Our Ref: 3147  
Your Ref: SSD-72430958

**State Significant Development Application for Finley Battery Energy Storage System**

Thank you for the opportunity to provide comment on the State Significant Development Application for Finley Battery Energy Storage System (BESS), at Riverina Highway, Finley NSW 2713.

Figure 31:
Pre-Development Scenario – Maximum
Flood Depth, 1% AEP Event

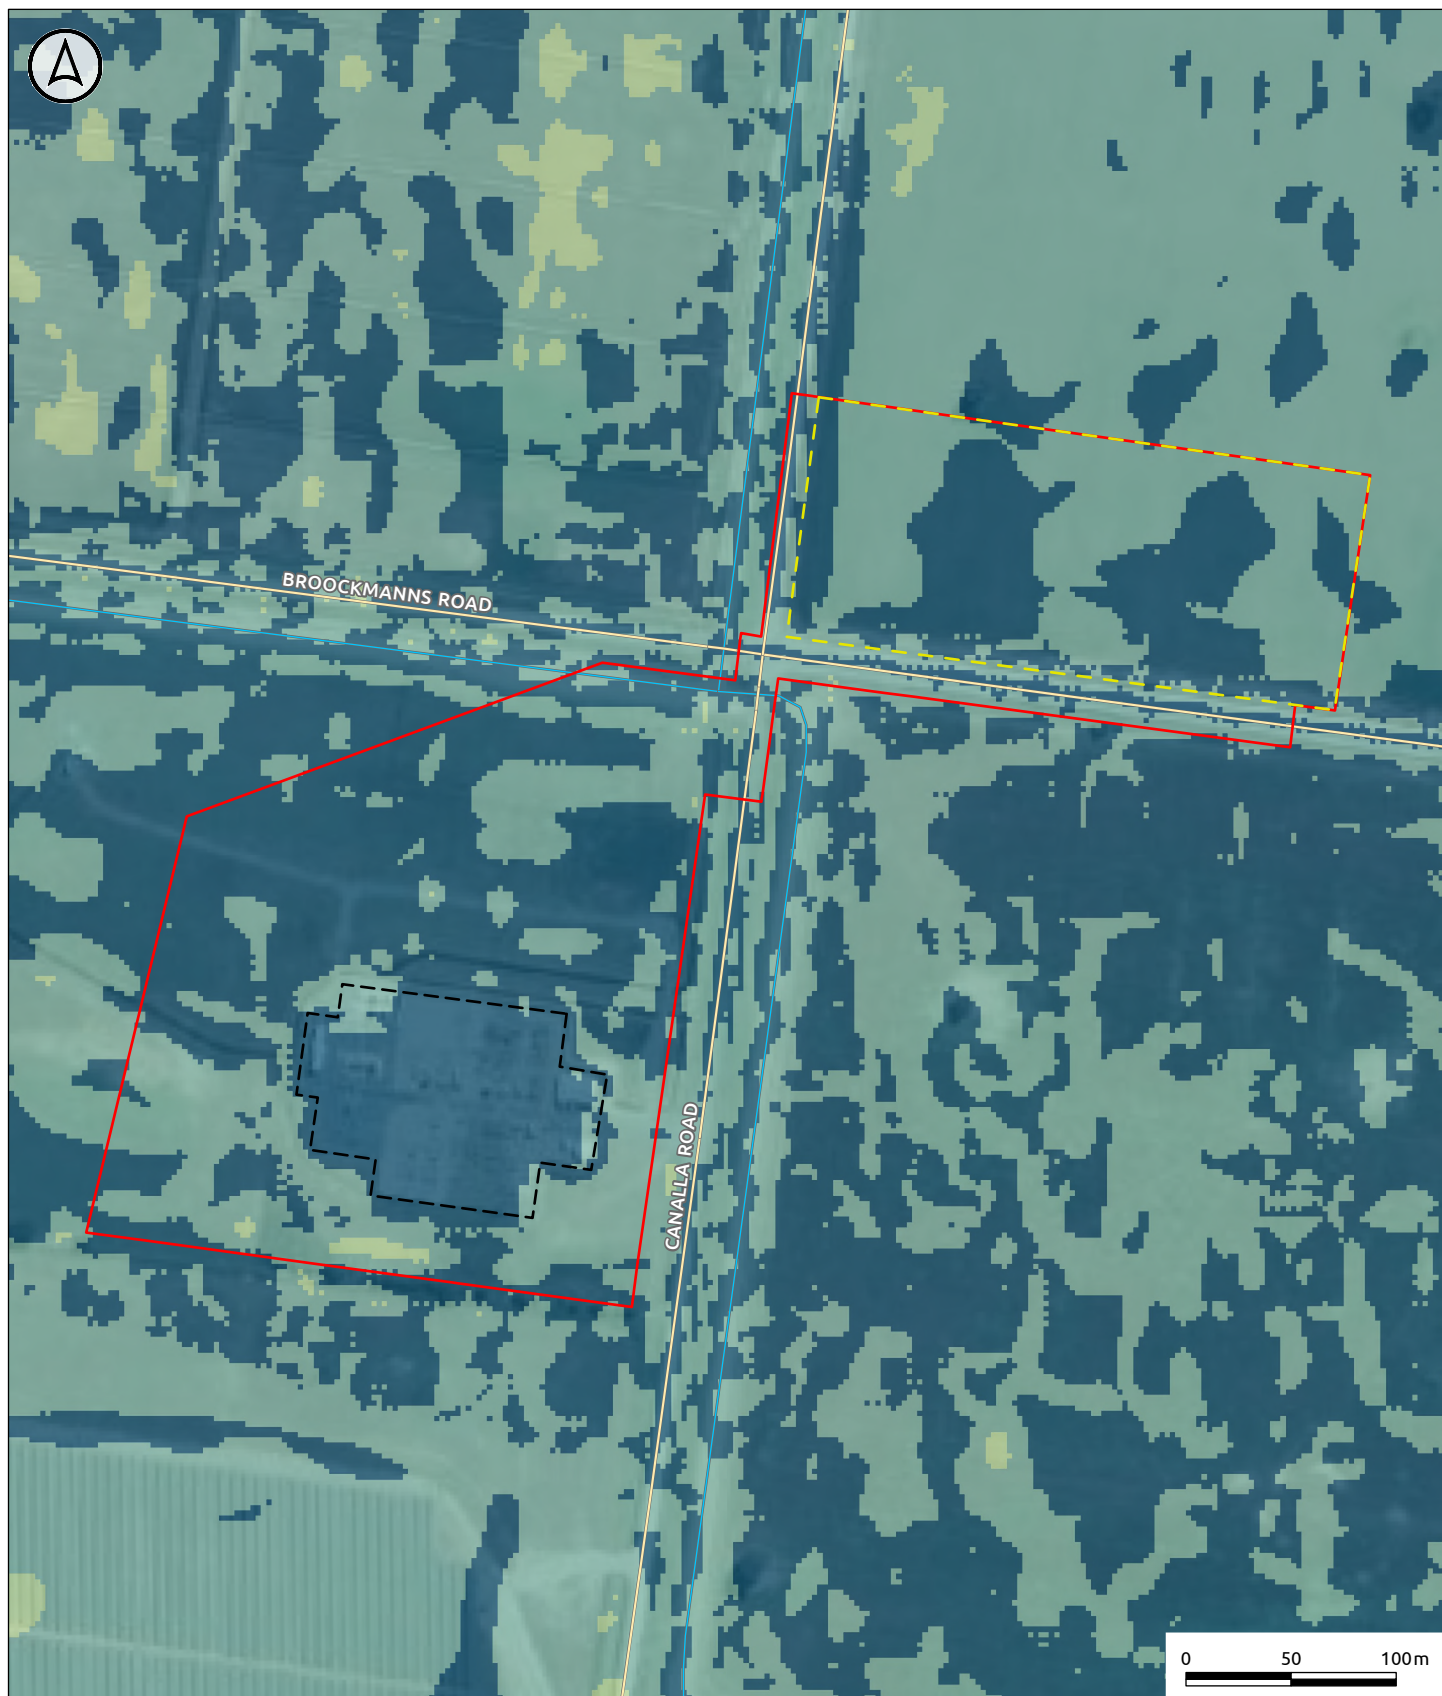
- **Note** the site and surrounding access roads are completely inundated in a 1% AEP event, with flood depths up to 0.5 metres in the pre-development scenario<sup>2</sup> and between 0.5 - 1 metres in some isolated areas of the site in post-development scenario.<sup>3</sup> However, more frequent or rarer events were not modelled to understand the full extent of the flood risks to life and property at the site, for example if the site becomes isolated prior to complete inundation.

It is understood that in a 1% AEP event, the site is completely inundated with flood depths up to 0.5 metres in the pre-development scenario.<sup>11</sup> In the post-development scenario, flood depth can reach 1 metres depth in some isolated areas.<sup>12</sup> We further note that the access roads, Broockmans Road and Canalla Road, are also completely inundated with up to 0.5 metres depth and H1 – H2 flood hazard level in a 1% AEP event,<sup>13</sup> however more frequent events were not modelled to understand if the site becomes isolated prior to inundation, and neither were modelled higher magnitude event to understand the full extent of the flood risks to life and property at the site.
